From: Amanda Scholes on behalf of Planning.Responses
Sent: 20 January 2021 10:28
To: Planning Scanning
Subject: FW: Y/140/20/DOC - Cinders Lane Nursery and works to the rear, Cinders Lane, Yapton, BN18 0JJ

Env Health Consultation advice on lighting.

Scale : 1:500 @ A1 Date : SEPT 2020
Drawing No : 97_17_103

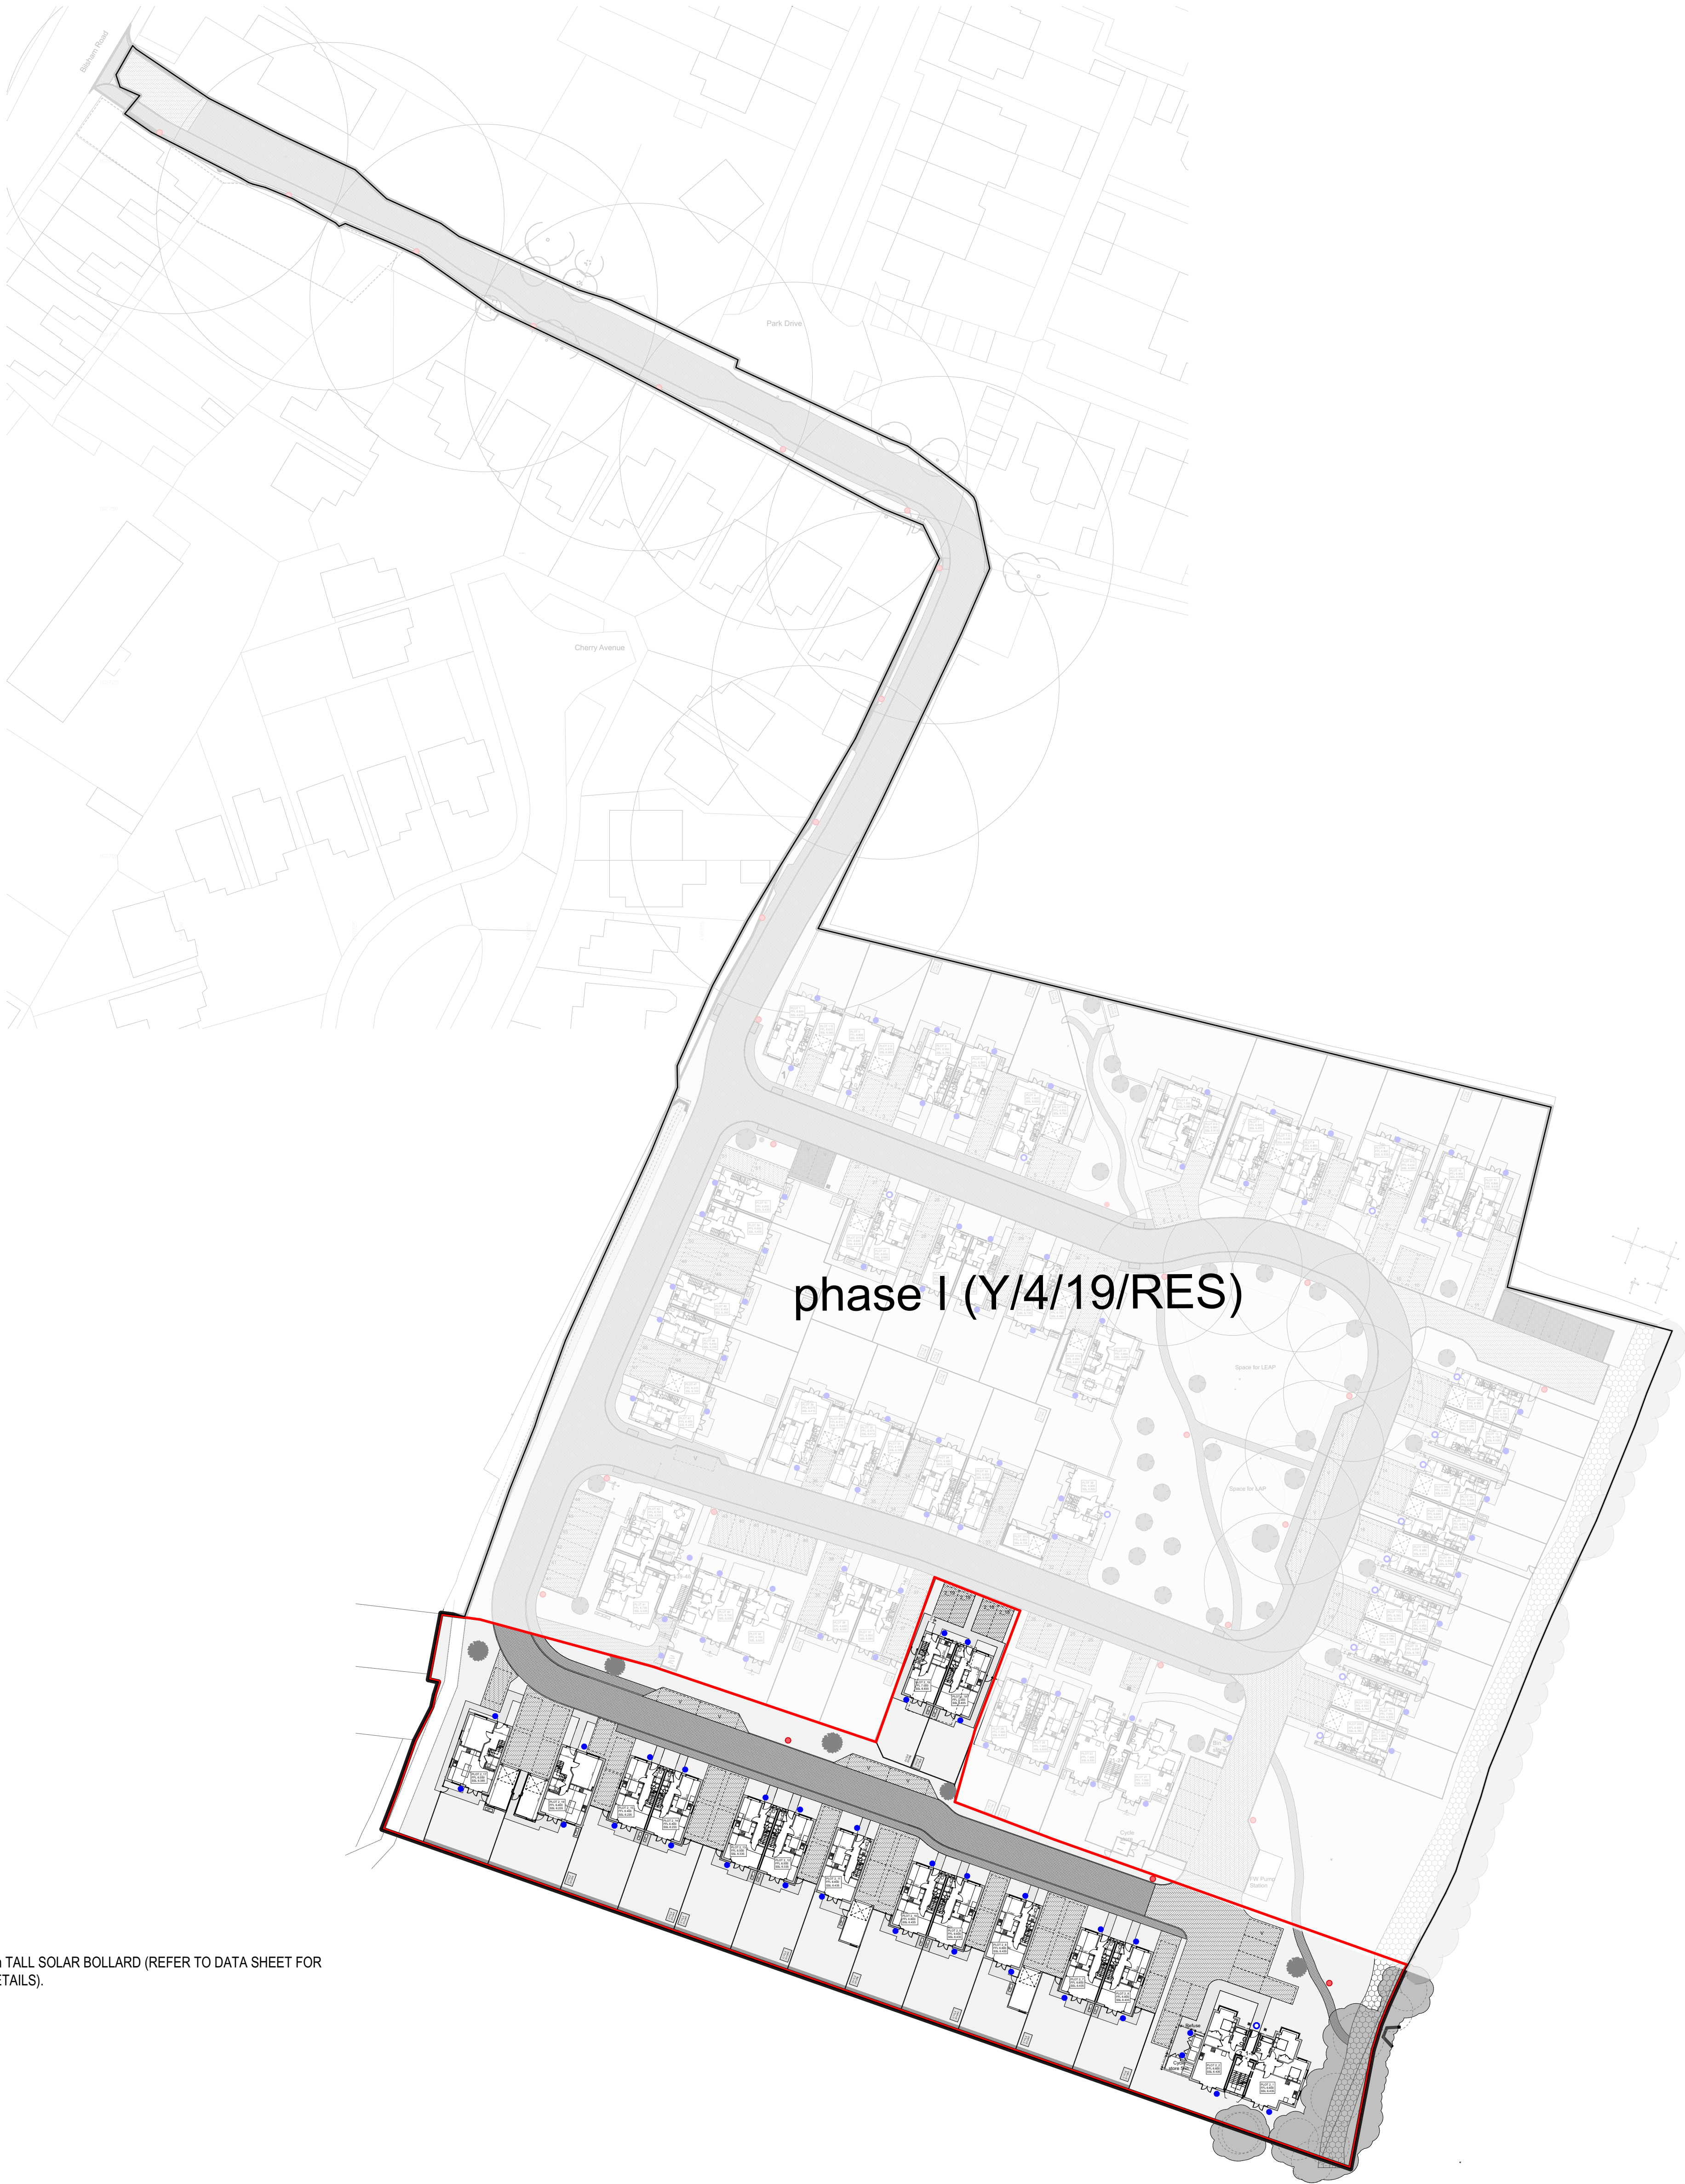
We have no concerns with the light emissions from the solar bollards. However, your response does not consider the other proposed light fittings on the site i.e. to the houses. Can a light spill diagram be provided for these?

Apologies for the delayed response. Having discussed with my colleagues, I understand the proposed Lutec radius wall lights were selected following quite in depth discussions on another of our projects in Arun DC where impact on bats was a concern (Orchard Business Park ref: Y/49/18/PL).

I have attached an additional datasheet which provides a bit more detail than the one submitted with the DOC application.

The recessed spotlights are only proposed under canopies or set back porches (as Phase I) so again I don't believe these should cause concern.

As with the bollard lights, both of these fittings were approved for phase I so hopefully with the benefit of the attached you will be in a position to discharge the condition.
